**Our Case Number:** ABP-318816-24

**From:** Housing Manager DAU <Manager.DAU@npws.gov.ie>  
**Sent:** Friday, March 1, 2024 12:45 PM  
**To:** LAPS <laps@pleanala.ie>  
**Subject:** Your Ref: ABP-318816-24 Our Ref: SID-OY-2024-001

Your Ref: ABP-318816-24  
Our Ref: **SID-OY-2024-001**  
(Please quote in all related correspondence)

**Proposed Strategic Infrastructure Development (SID): SID Planning Application for**  
(i) 8 no. wind turbines with hub height of 114 metres, a rotor diameter of 172 metres and an overall tip height of 200 metres; (ii) all associated turbine foundations and crane hardstanding areas; (iii) a wind farm control building with a gross floor area of 131 square metres; (iv) underground electrical and communications cabling; (v) Construction of internal wind farm access tracks and the upgrade of existing agricultural and forestry tracks; (vi) upgrade works to 2 no. existing site entrances from the N62 national secondary road to provide access for the construction phase; (vii) Upgrade works to 2 no. existing site entrances from the L30033 and L300321 local roads to provide access during the operation phase; (viii) 1 no. guy-wired meteorological mast with an o

Drawing No.:	Revision No.:	
CUS_PAS_LOC_002	0	
Scale:	Date:	
(A1) 1:10,000	05/12/2023	
Drawn By:	Checked By:	Confirmed By:
C.M.P	D.O	S.C.

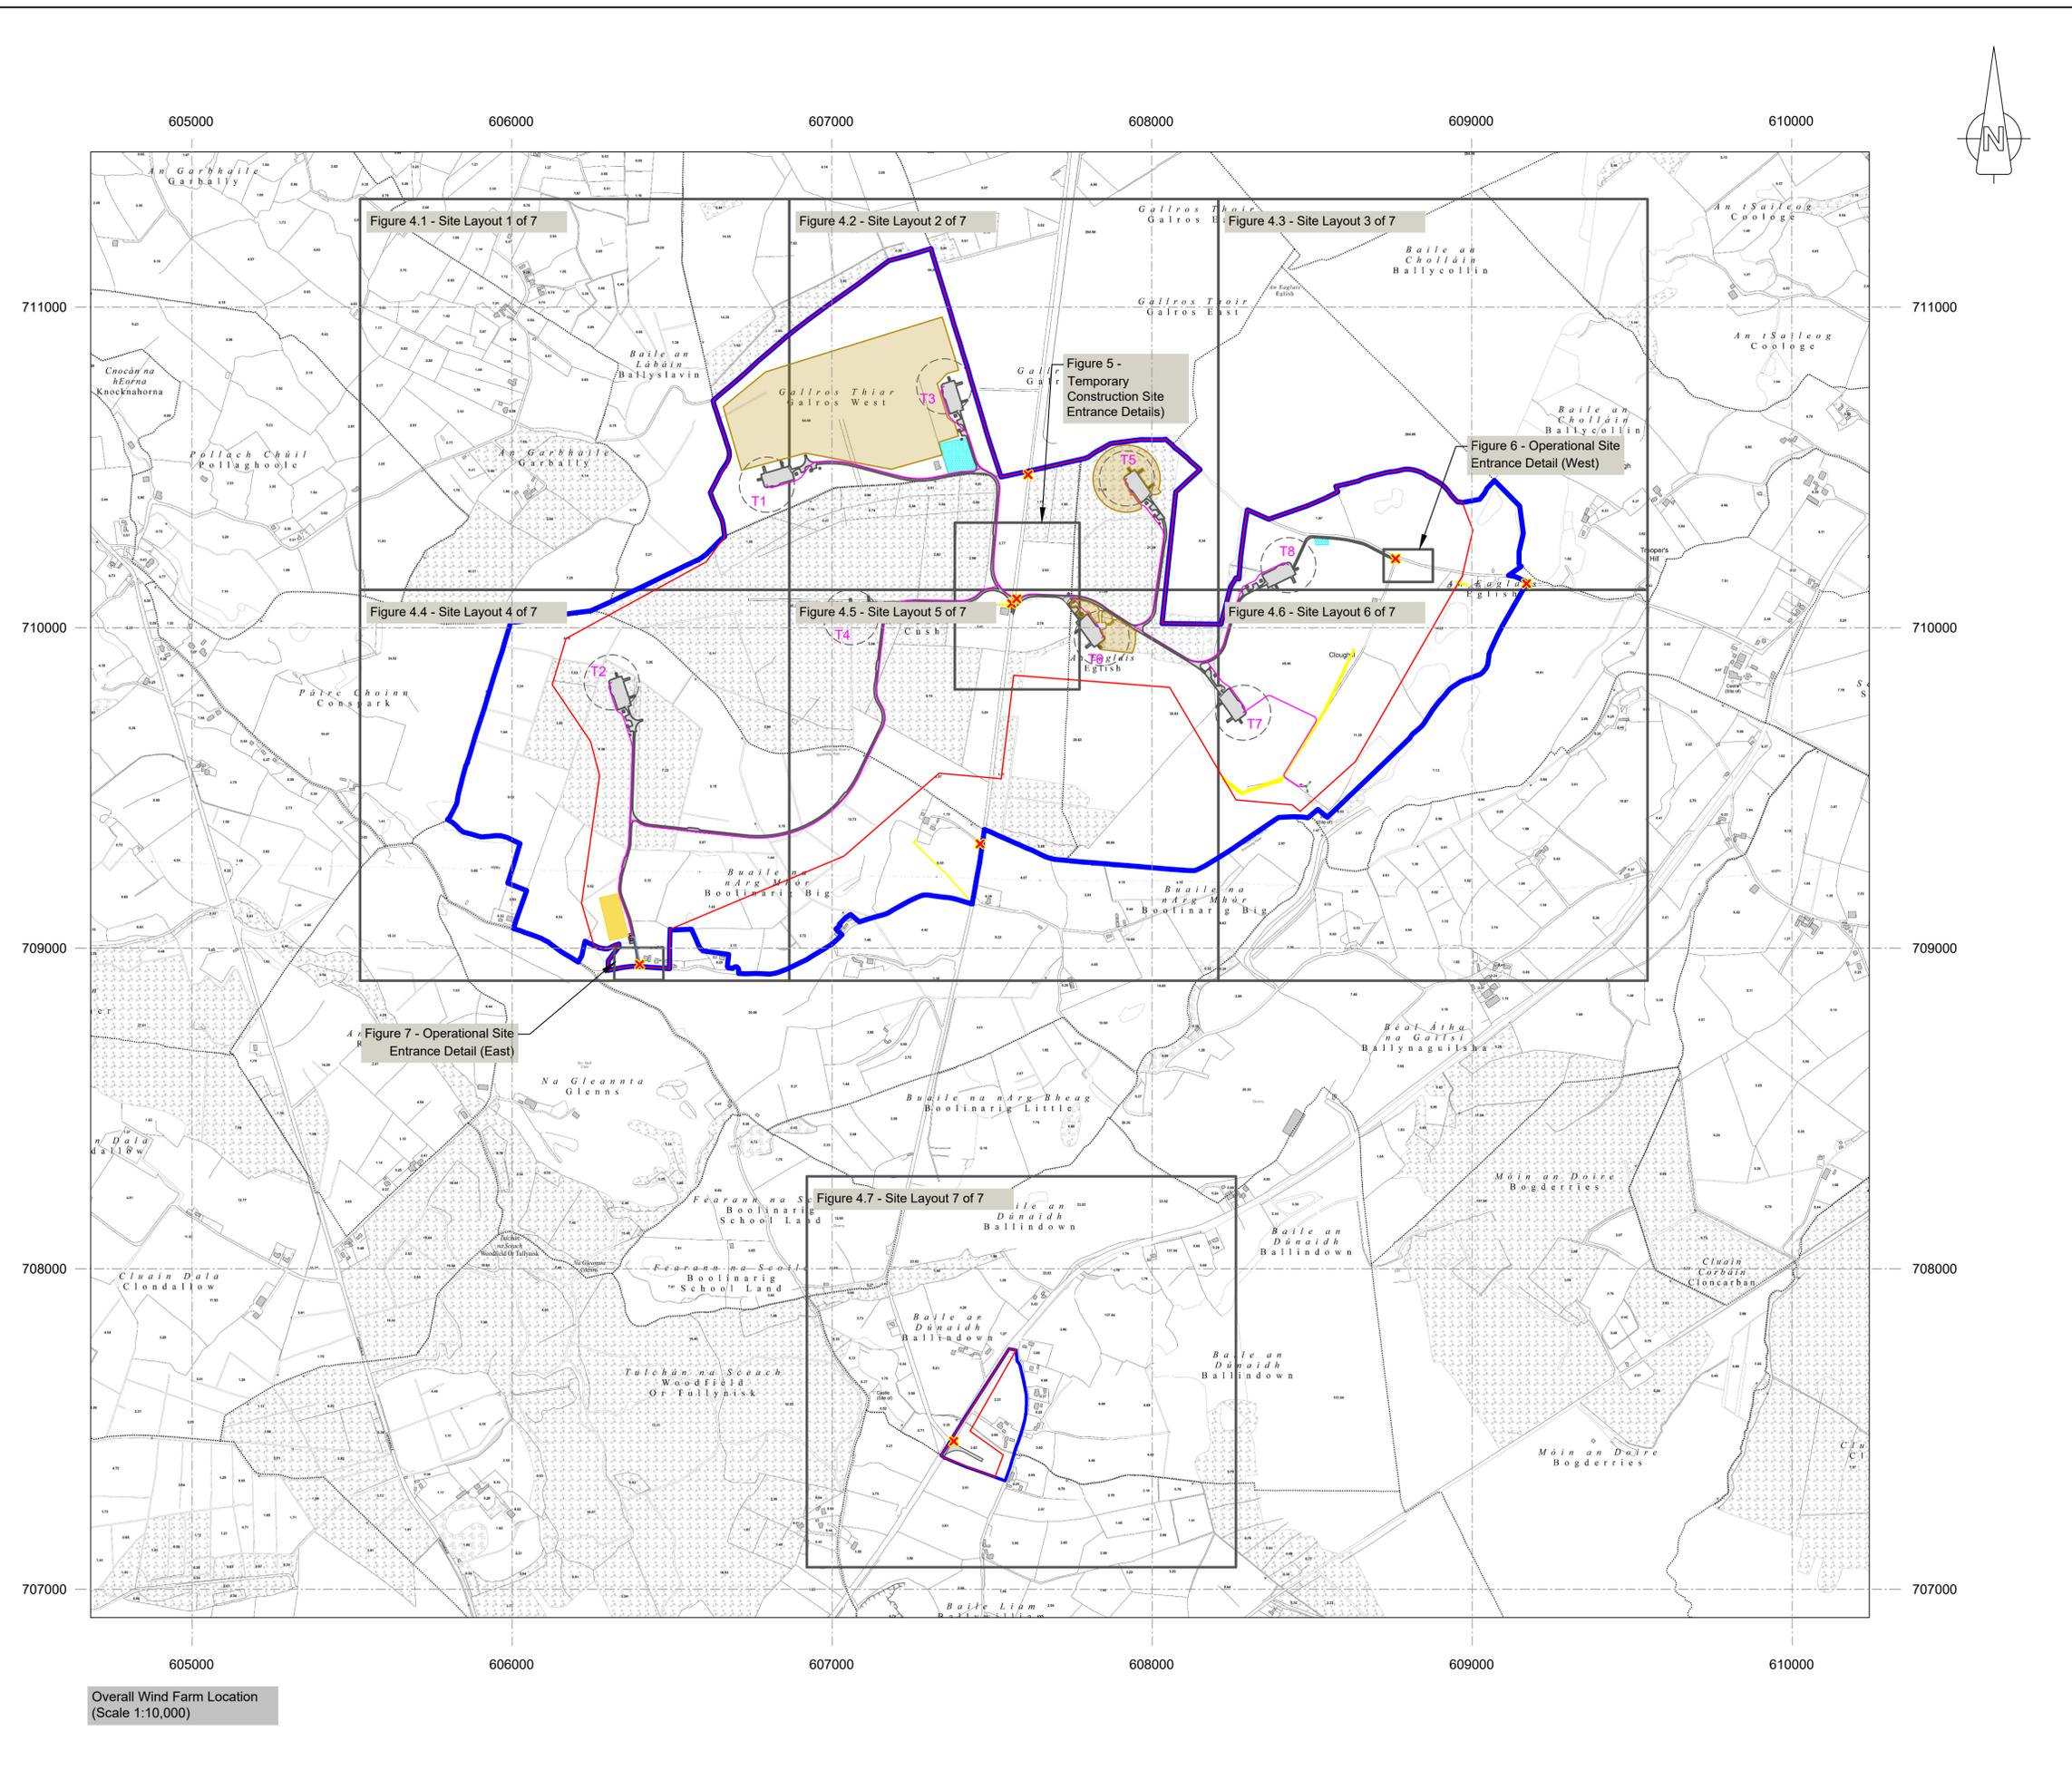
compound and spoil deposition. From reviewing Drawing Number CUS\_PAS\_LOC\_002, it is noted that the largest spoil deposition area within the site is located directly adjacent and may overlap potential Raised Bog habitat. The impacts of this on any raised bog habitat present must be assessed.
